Charlotte Storm Water
600 East Fourth Street
Charlotte, N C 28202-2844

Rezoning Petition Review

Date of Review: April 20, 2020

Rezoning Petition #: 20-38

RE-ZONING EXHIBIT

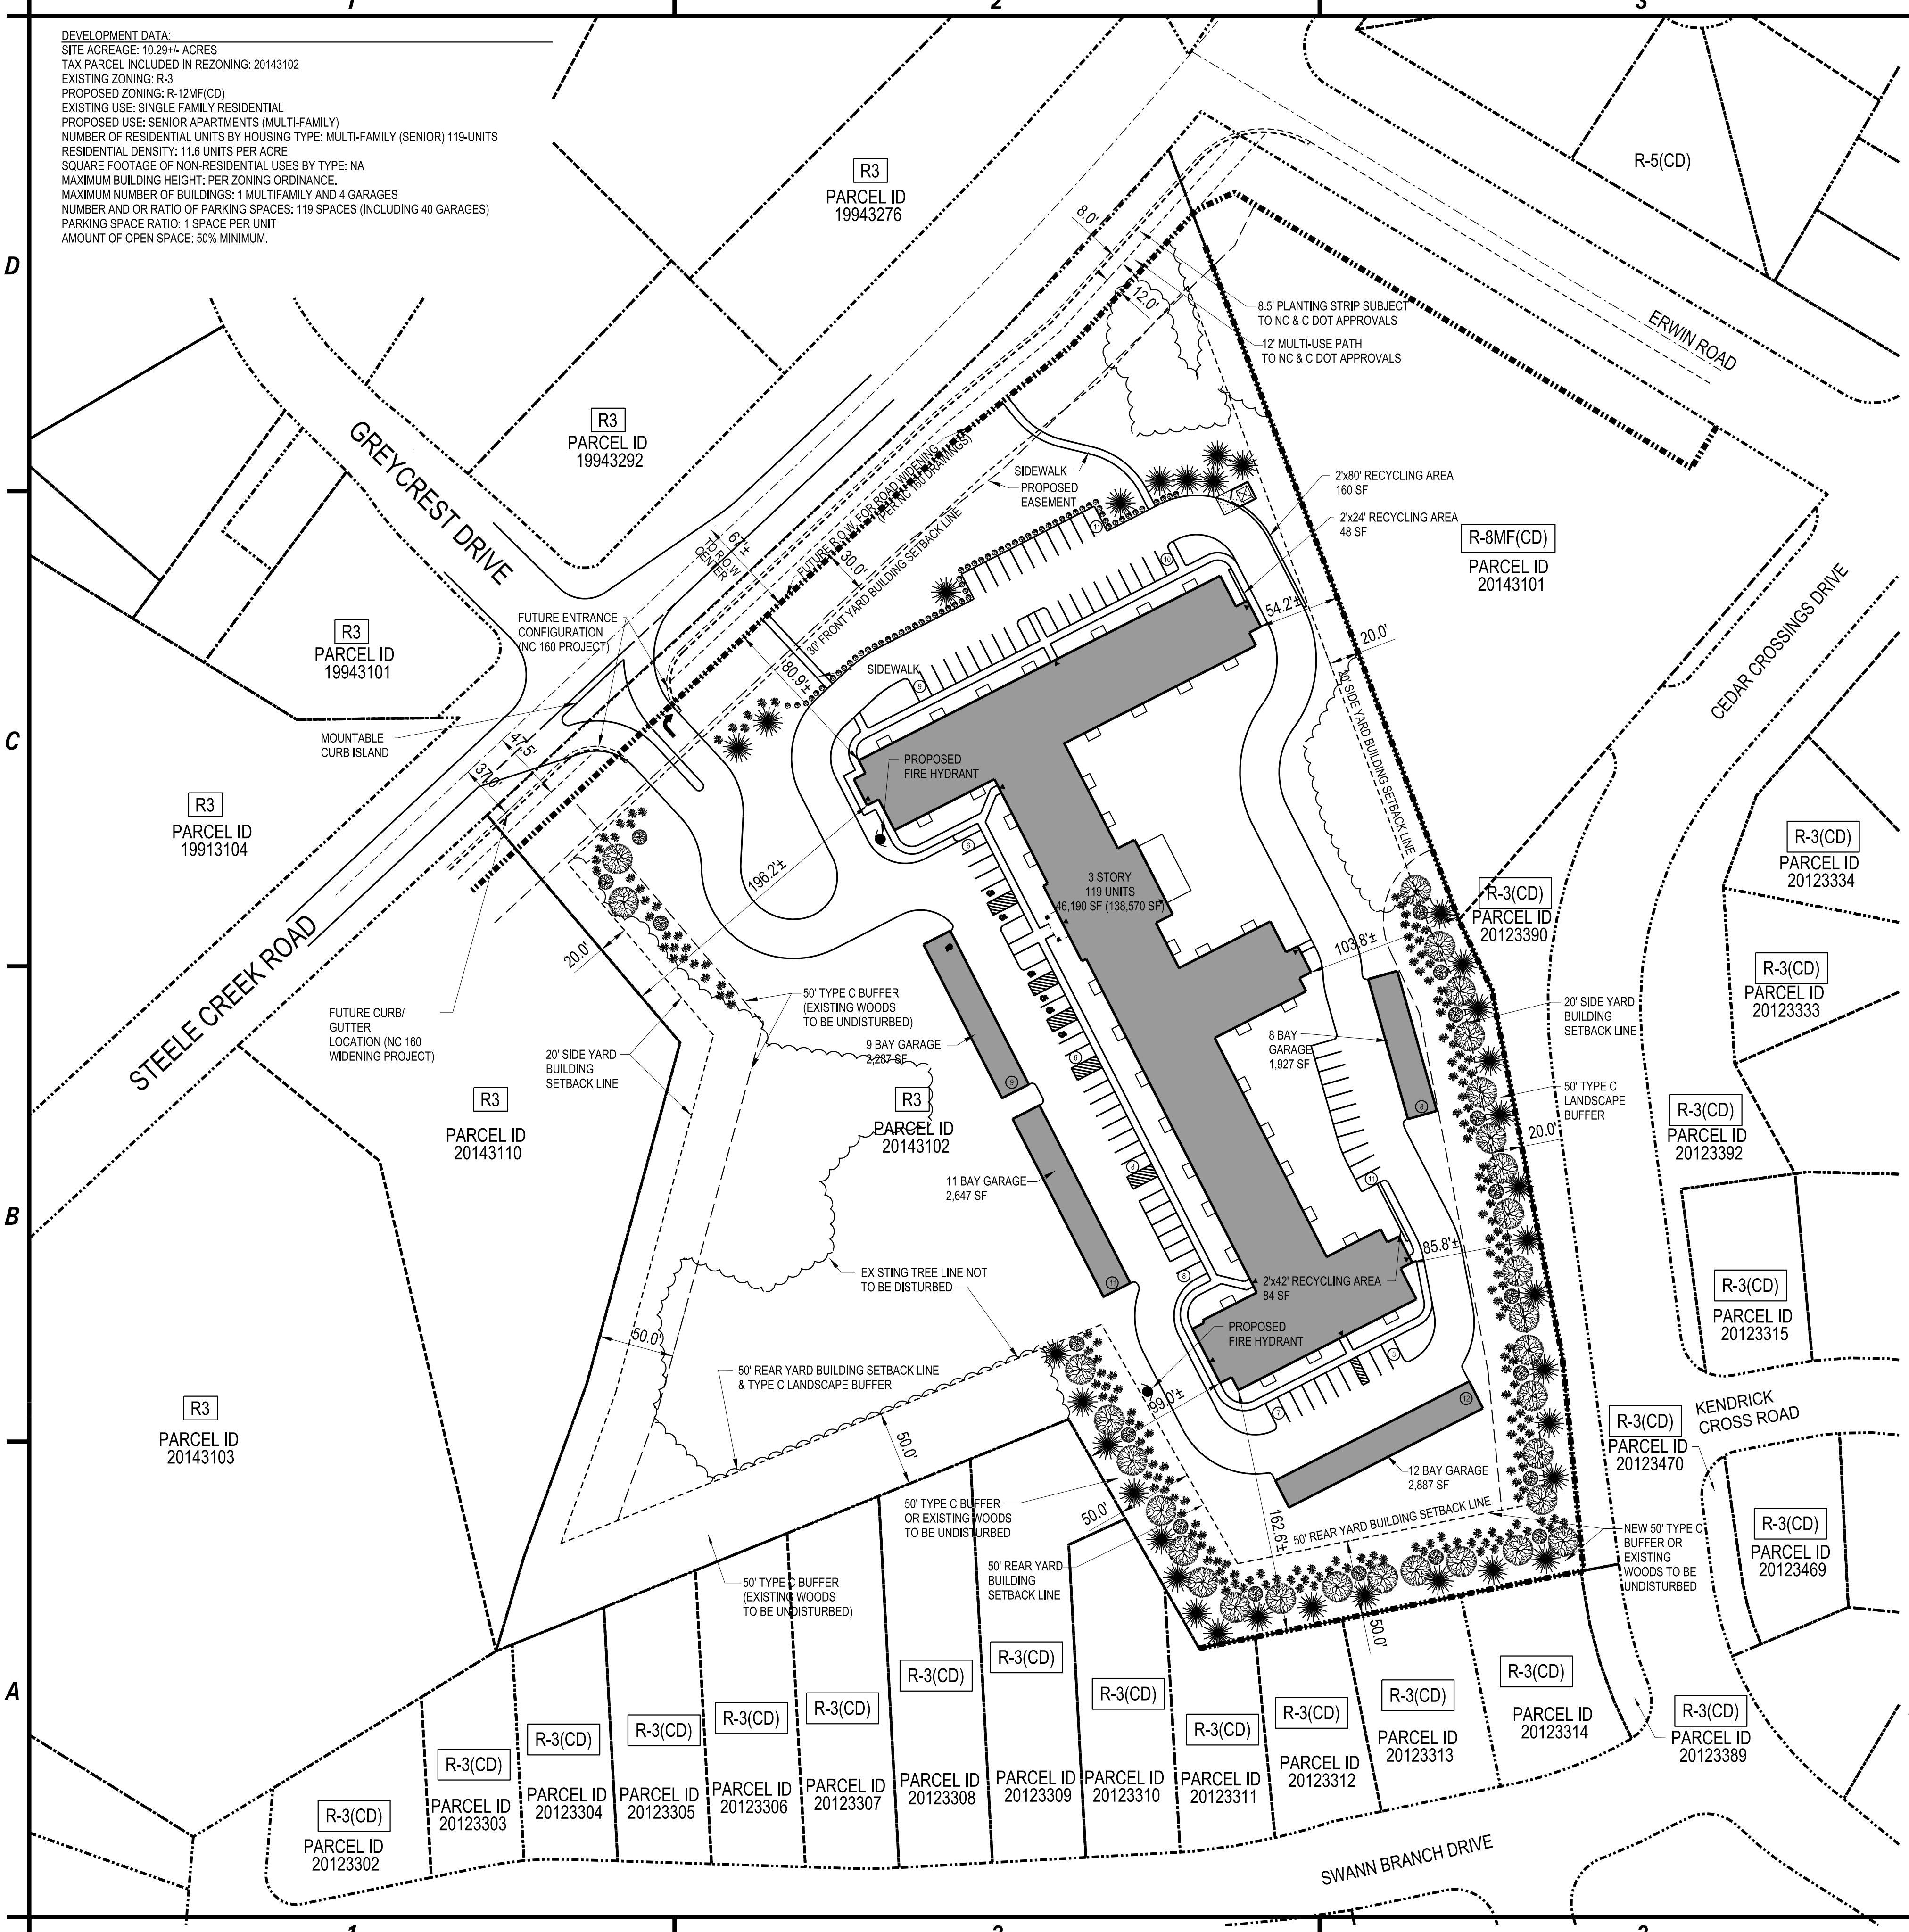
Recommendations Concerning Storm Water: Please include the following note under Environmental Features. *For adjoining parcels receiving storm water discharge the petitioner shall analyze the adequacy of the existing storm water conveyance on the adjoining parcels to the downstream channel (identified by the SWIM/PCSO buffer on PID 20143103). If the existing storm water conveyance on the adjoining parcels is found to be inadequate, the Petitioner shall make a good faith effort with the property owner(s) to improve the storm water conveyance or mitigate the storm water discharge onto the adjoining parcels.*
